| <b>Environmental Health Consultation Response</b> | <b>Officer</b> | <b>Alan Taylor</b> |

**Detail: Planning request 3/2018/0712**

| <b>Address:</b>         | <b>Four Acre Land Longridge BB7 2AH</b> |                      |                   | <br><b>Ribble Valley<br/>Borough Council</b><br><a href="http://www.ribblevalley.gov.uk">www.ribblevalley.gov.uk</a> |
| <b>Application Ref:</b> | 37211                                   | <b>Case Officer:</b> | rebecca halliwell |   |

Proposed
 Site Plan
 DATE July 2017

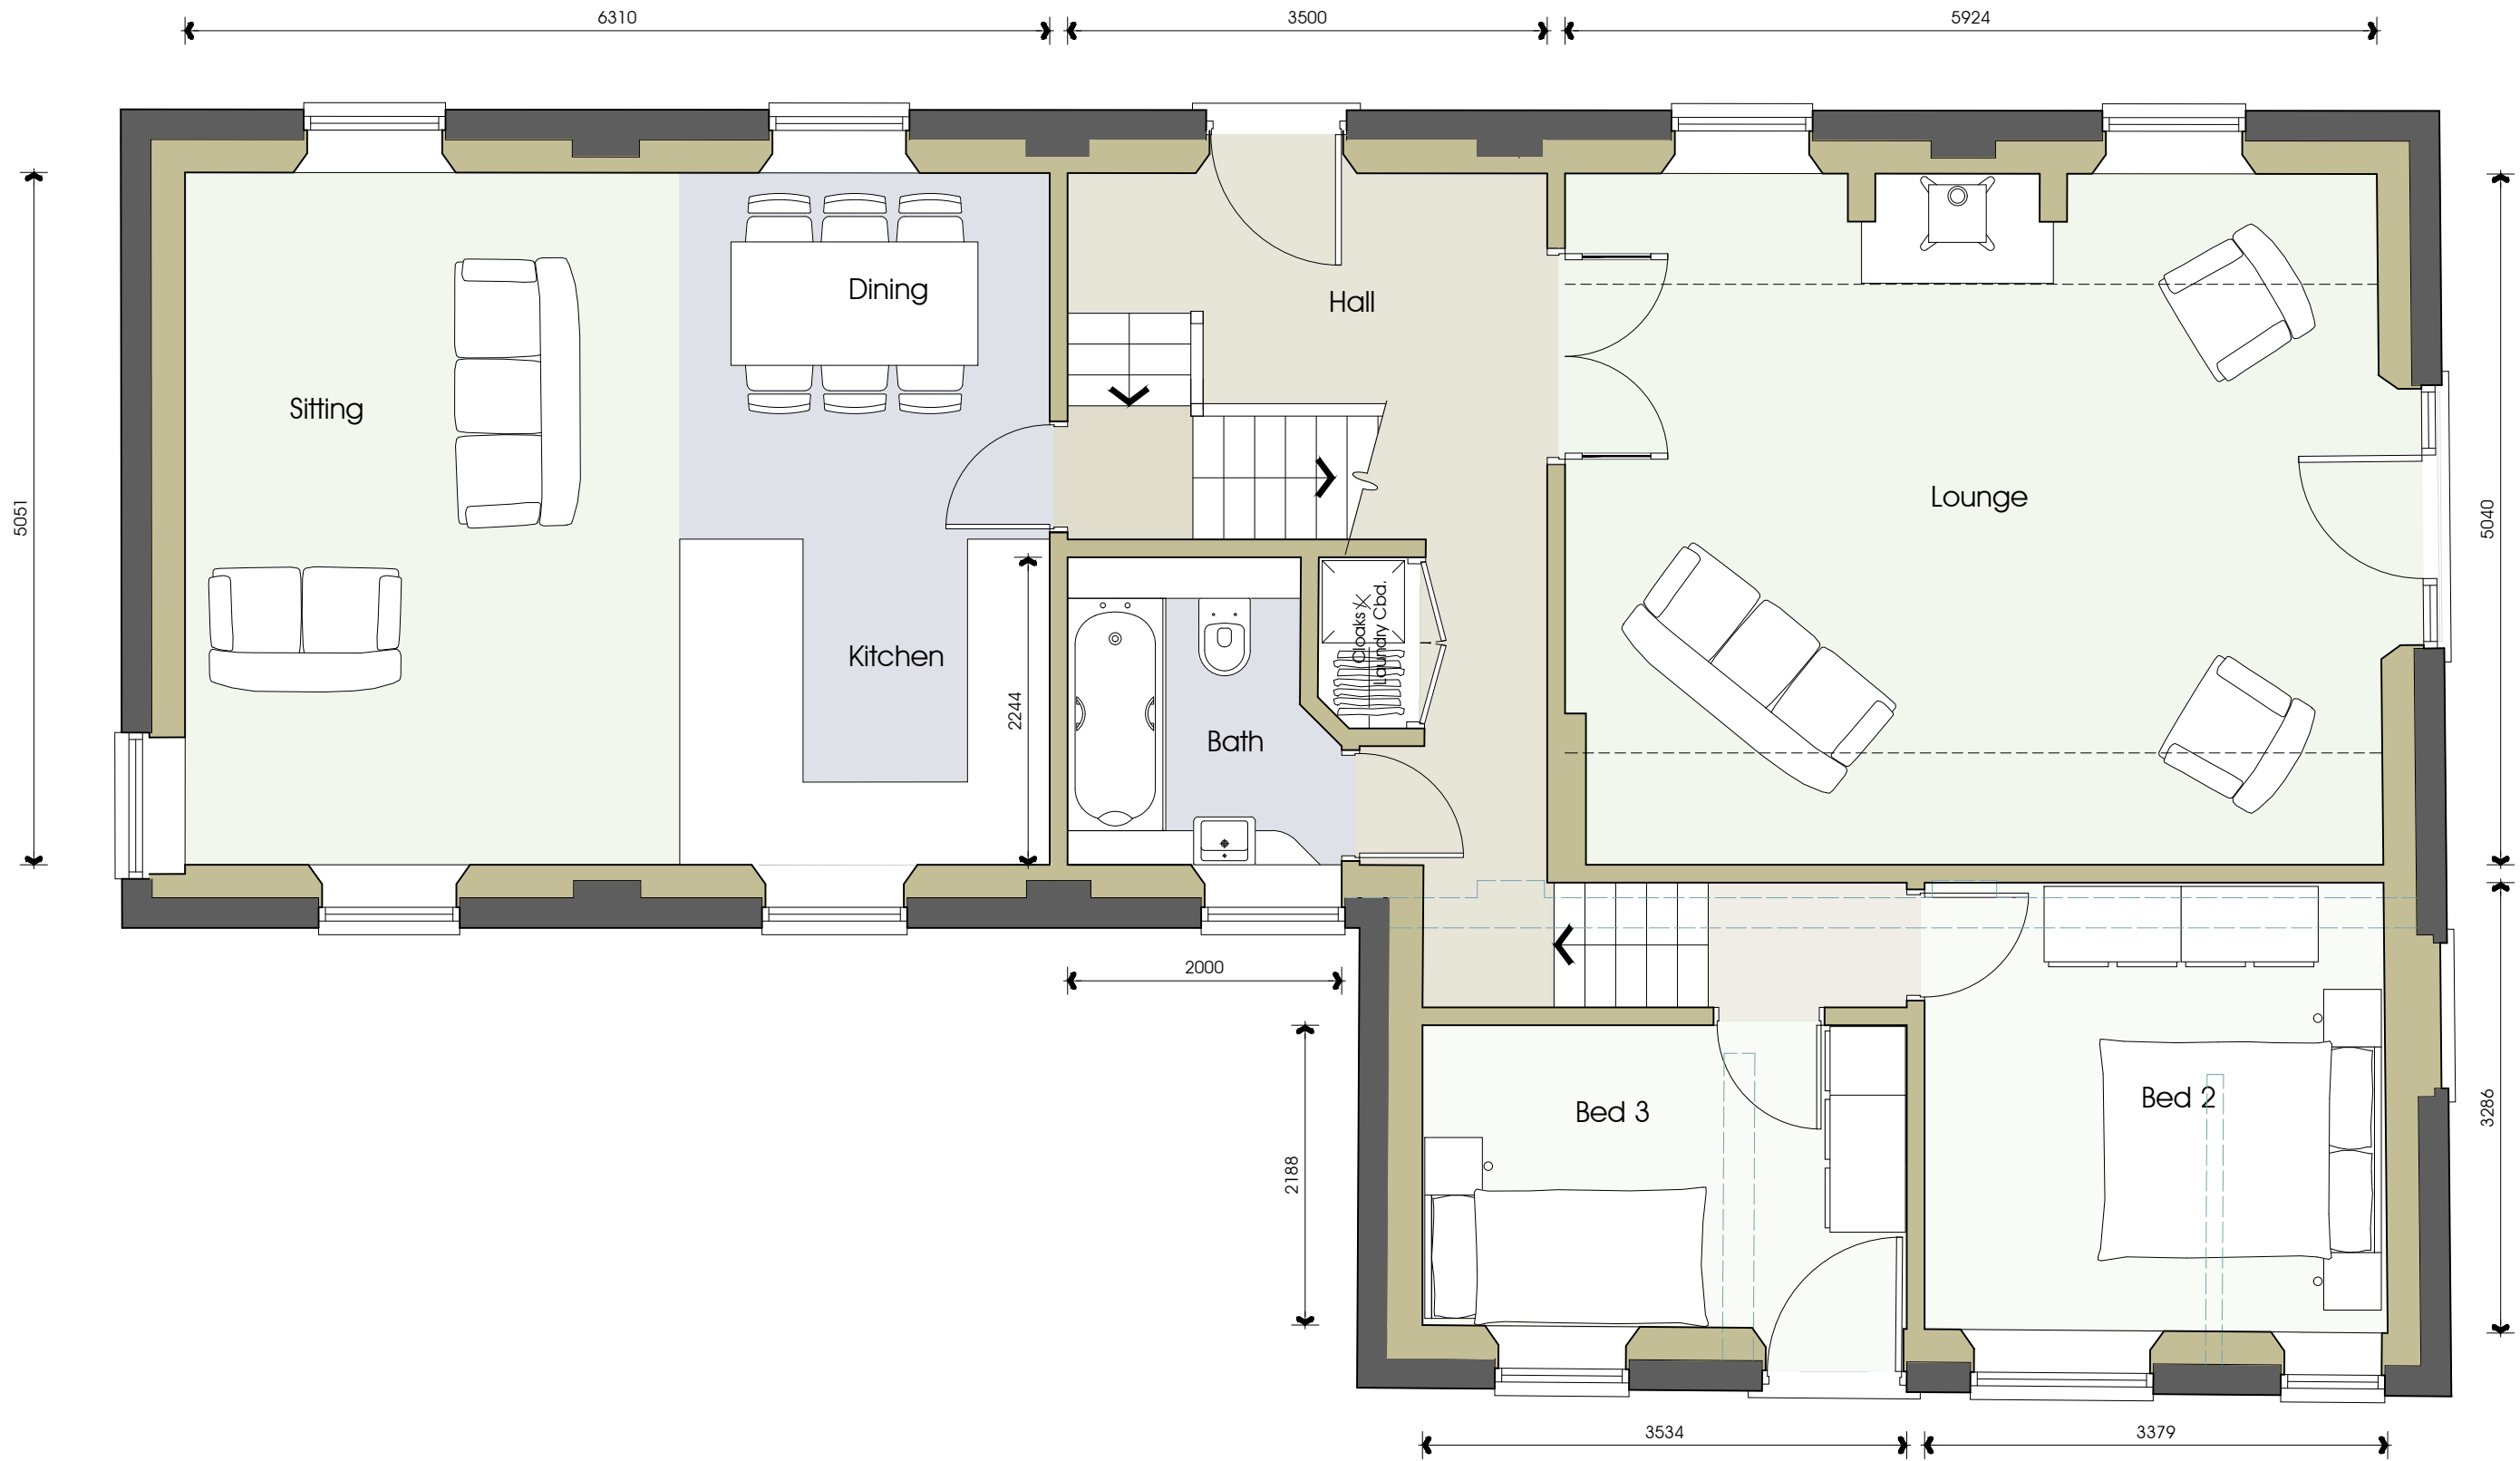
| <b>2.1</b>                              | No comments in general of the application, but there is no indication on the location of the Klargester sewage package treatment plant. As there a water course near by the Environment Agency should be informed of the use of the Klargester for sewage treatment. |
